COUNCIL SUBMISSION

SSD 10459 – CENTRAL SYDNEY INDUSTRIAL ESTATE AND DOWNER SUSTAINABLE ROAD PRODUCTS COMPLEX

I refer to the public exhibition of the above application for subdivision and infrastructure works to create the Central Sydney Industrial Estate and Stage 1 works for the development and operation of Downer's Sustainable Road Products Complex.

Drawing Title:
Streetscape Plan - Proposed Access Road

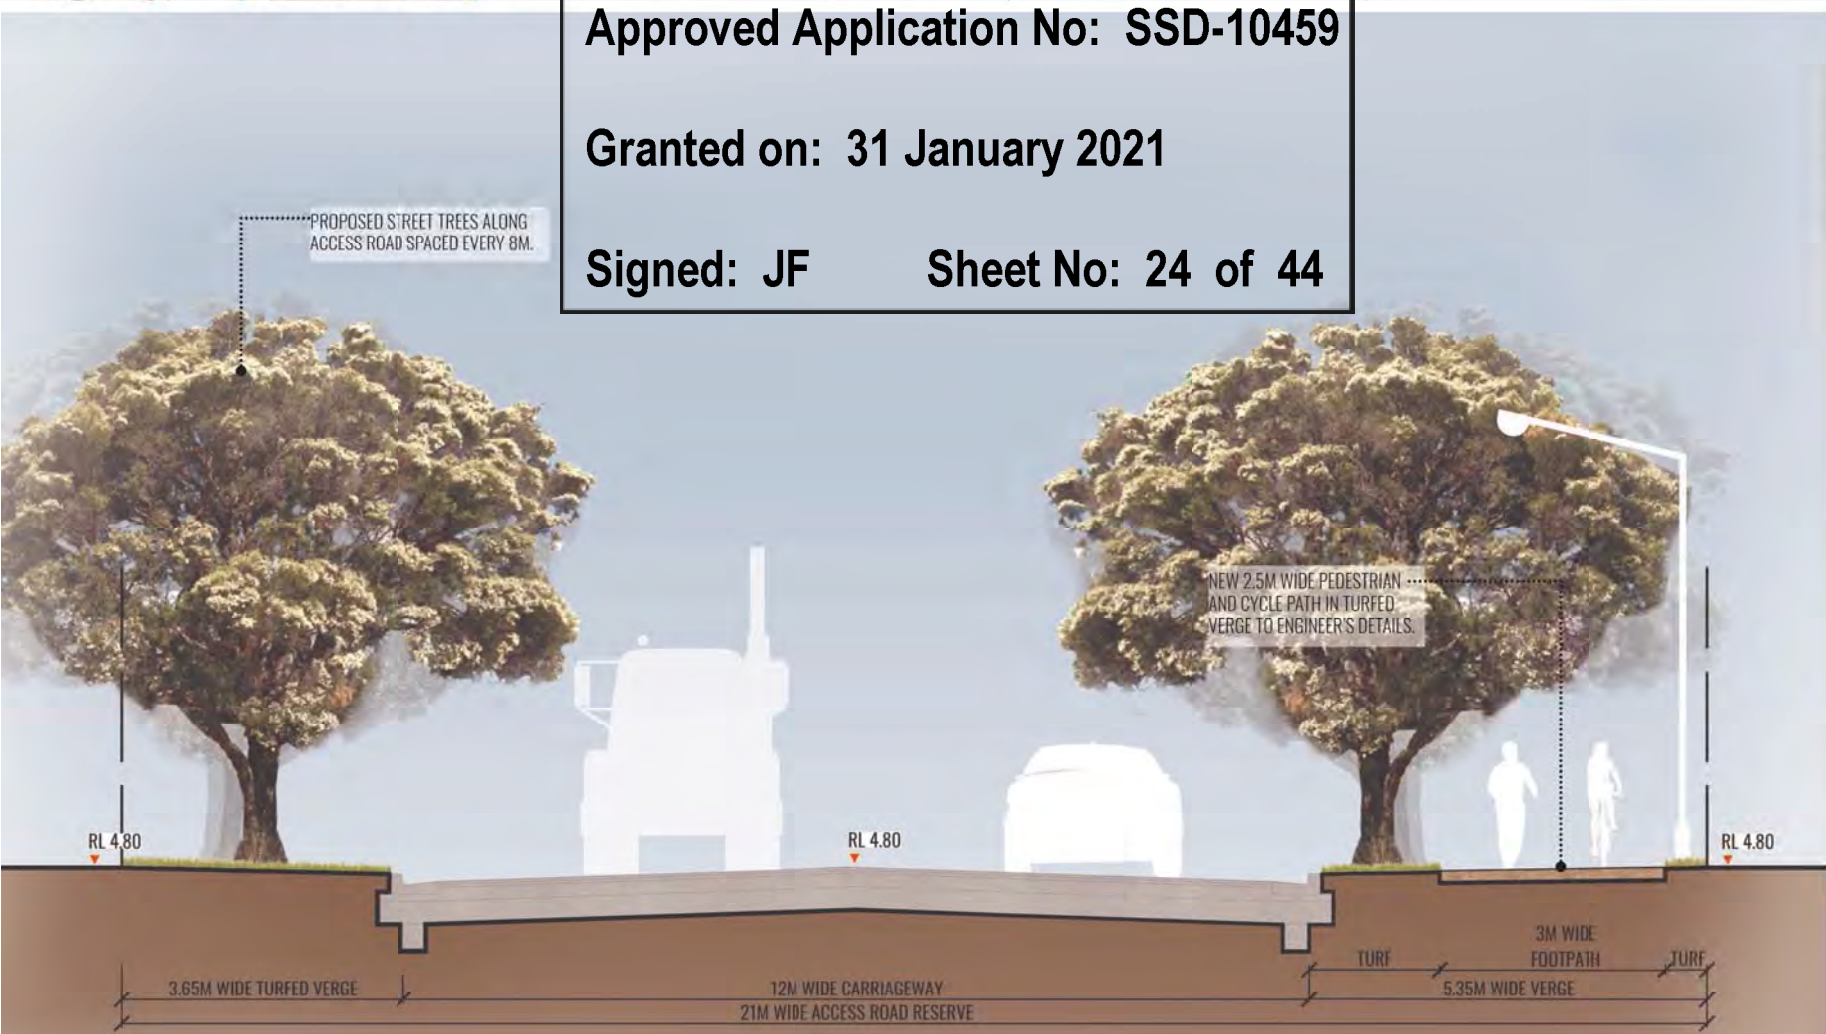
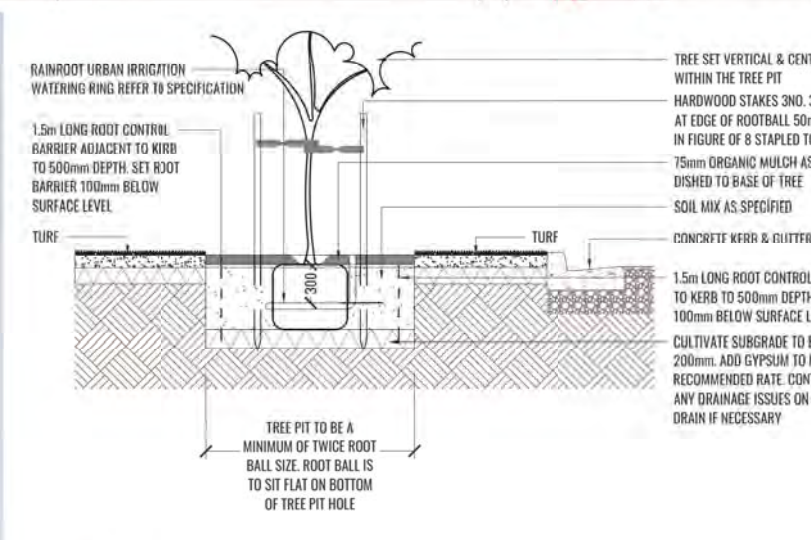
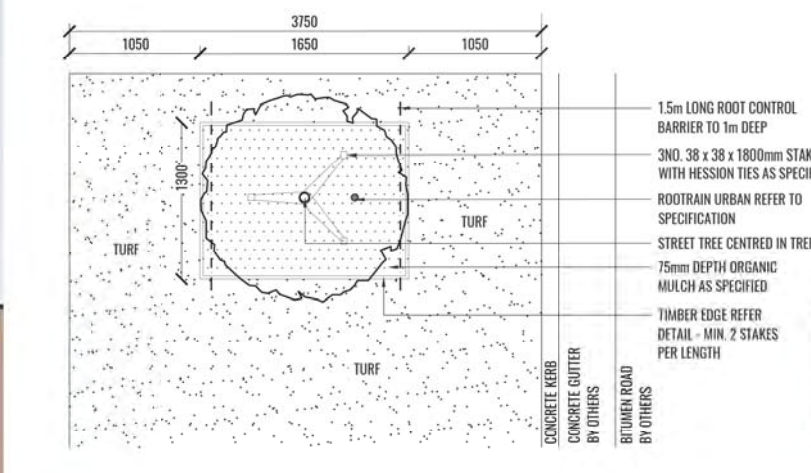
- Clarification is required whether the intent is to have a footpath proposed on both sides of the Access Road. The typical street section shows the footpath on one side only, however, the street tree planting details show a footpath adjacent to the trees;
- An increase to the swale species diversity from the limited 3 x species proposed of grasses and rushes to include at least a 8 – 10 species mix as listed in the revegetation species list should be provided within the VMP report;
- An increase in the bioretention basin planting mix from the limited 5 x species proposed of grasses and rushes to include at least a 8 – 10 species mix as listed in the Revegetation species list is requested to be provided within the VMP report;
- The engagement of a AQF Level 5 Arborist ('Project Arborist') to provide a Tree Impact Assessment, Tree Protection Plan and Tree Management Specification to

Drawing Title:
Riparian Corridor Section B-B
 DWG No: **SSD-09**

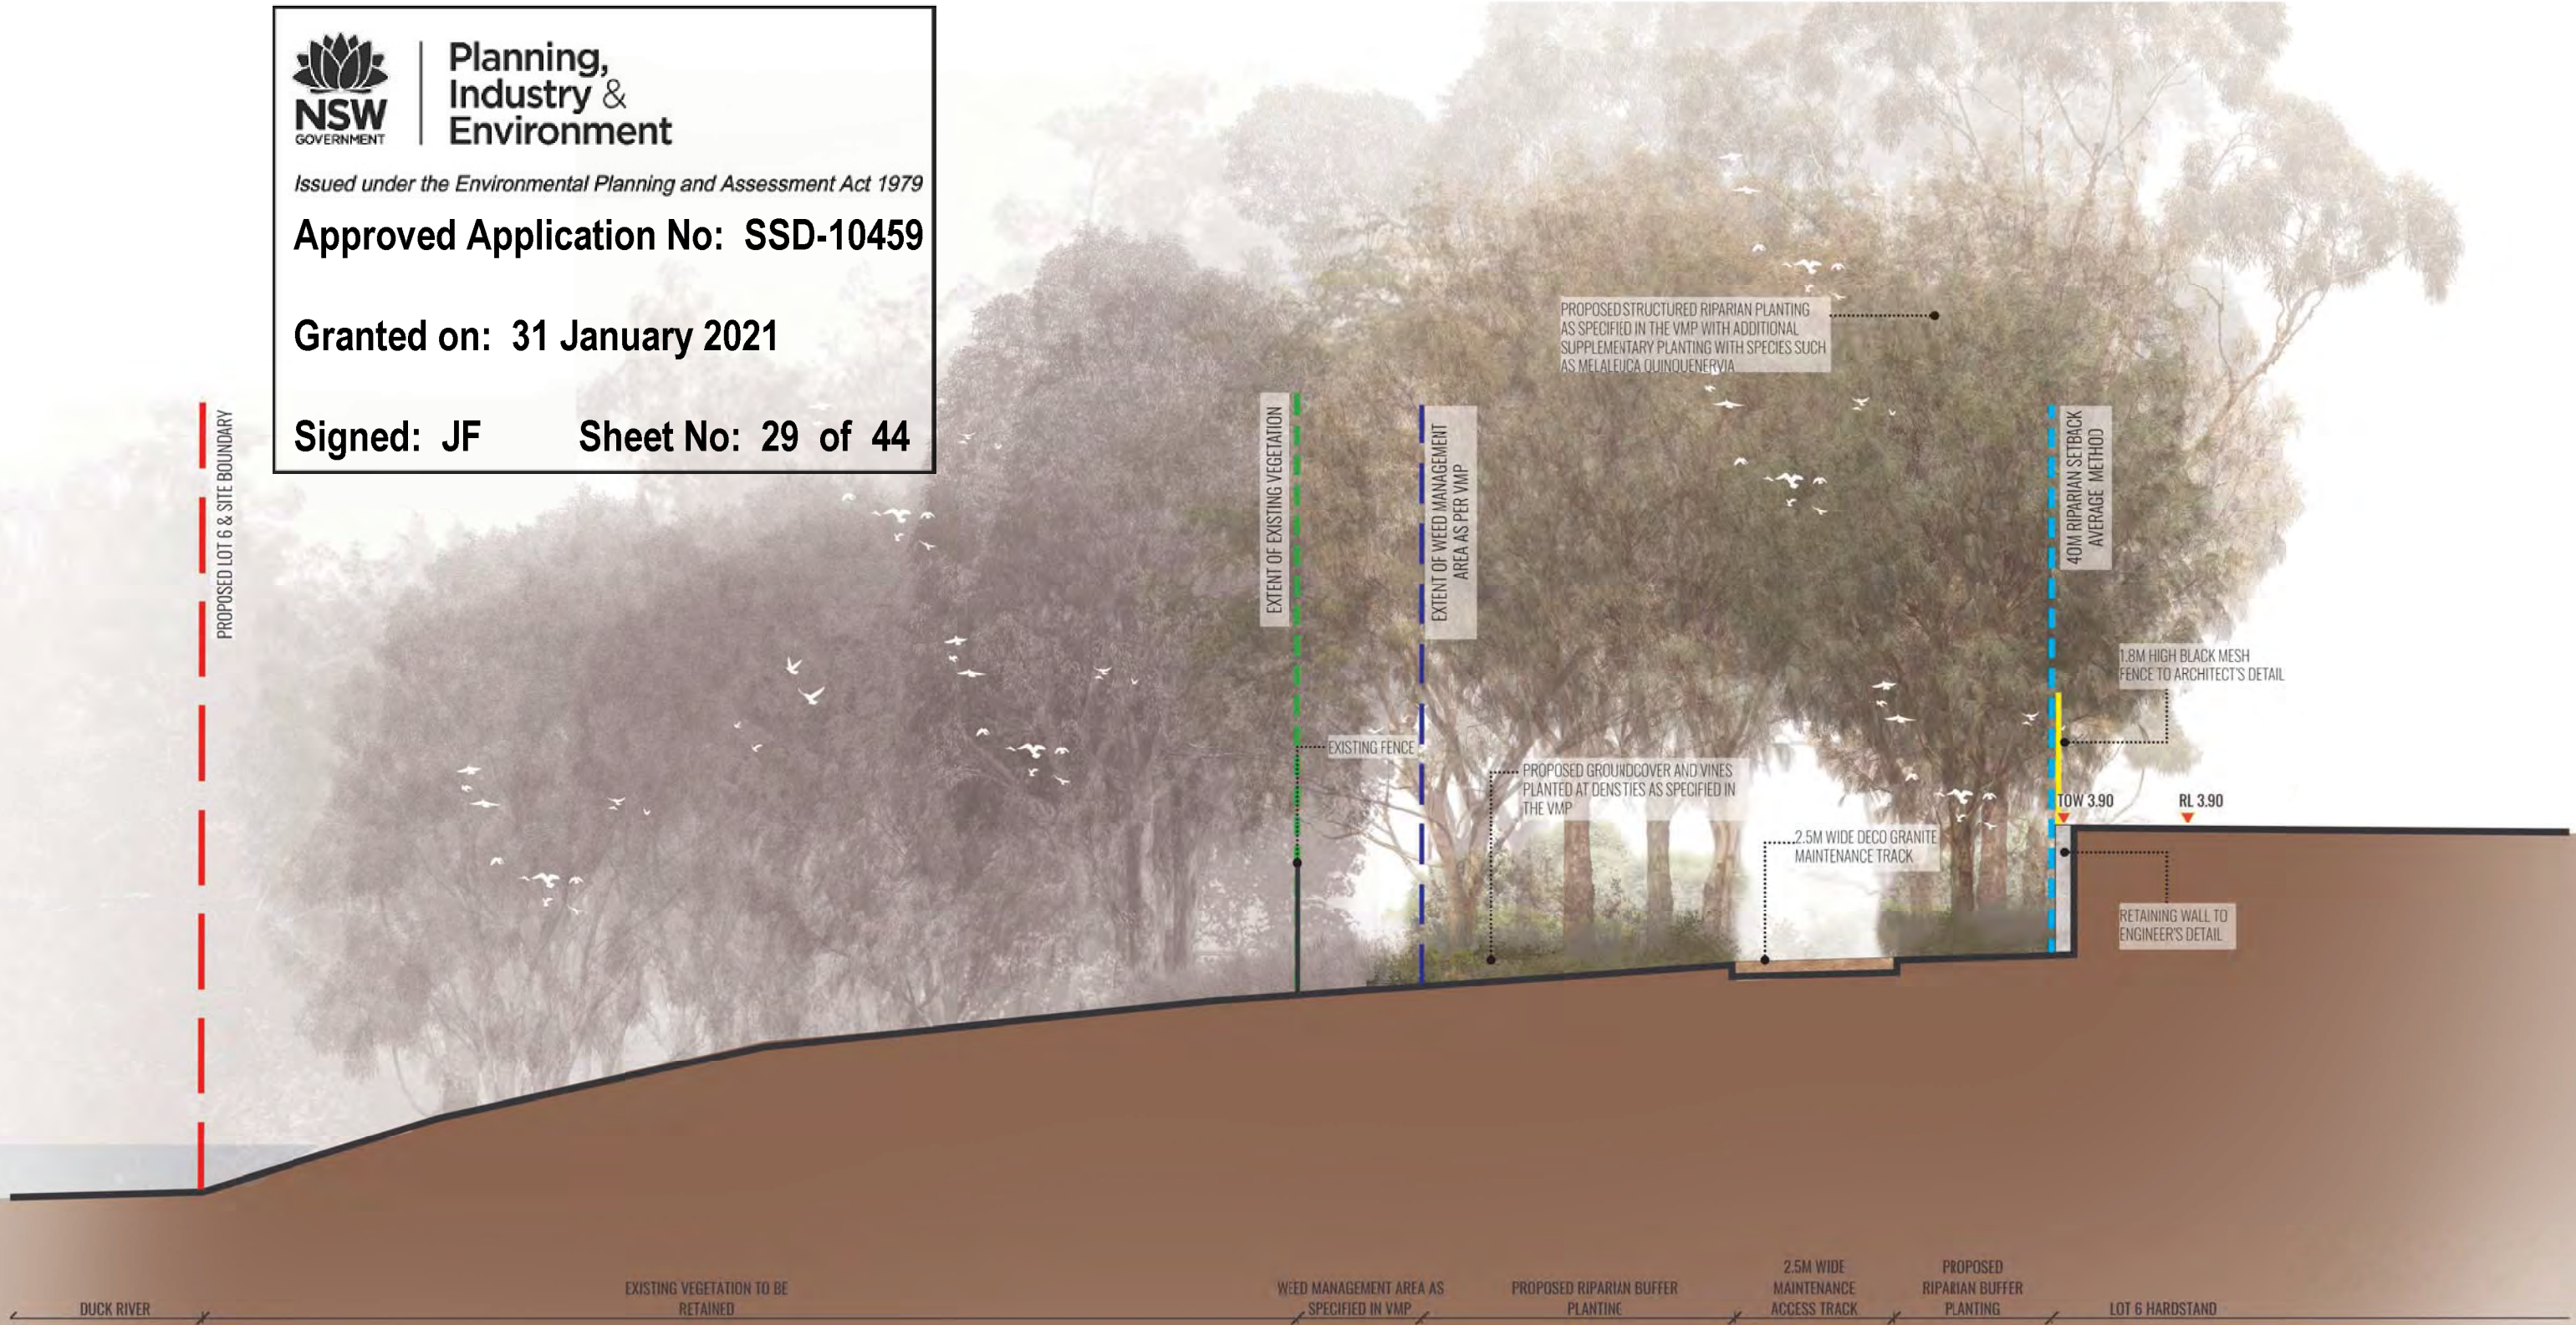
Duck River is tidal in this location, as evidenced by the presence of mangrove forest, which is also mapped as Coastal Wetlands. It is also mapped as Key Fish Habitat that typically requires a 50-100m buffer zone under NSW Fisheries guidelines. An increased average minimum width of 40m is therefore considered to be more appropriate and consistent with NRAR and NSW fisheries guidelines. This would provide greater capacity for the riparian corridor to accommodate a shared pedestrian cycleway without encroaching into the 30m core vegetated zone, with the cycleway to be located along the landward edge to maximise ecological functionality.

- Increase the width of the Duck River vegetated riparian zone to 40m from top of bank consistent with the Natural Resource Access Regulator 'Guidelines for controlled activities on waterfront land (Riparian Corridors)' for tidal waters.

The proposal incorporates a 2.5m wide deco gravel maintenance path that has been provided at the south of the site within the riparian corridor which is considered inadequate. Council is investing in separated walking and cycling along the Parramatta River as a 3m wide shared path is considered inadequate for the speeds and volumes of pedestrians and cyclists on the path.

- A separated walking (2m) and cycling (3m) path in concrete within the 40m from top of bank along the full extent of Duck River frontage. For areas where this is either ecologically or topographically challenging, this can be in the form of a boardwalk.
- Council shall be granted an easement for ongoing public access of this path. It is noted that no subdivision plans for approval have been provided and details of Council's role within the easement. Further detail must be provided to ensure Council are satisfied with the easement.
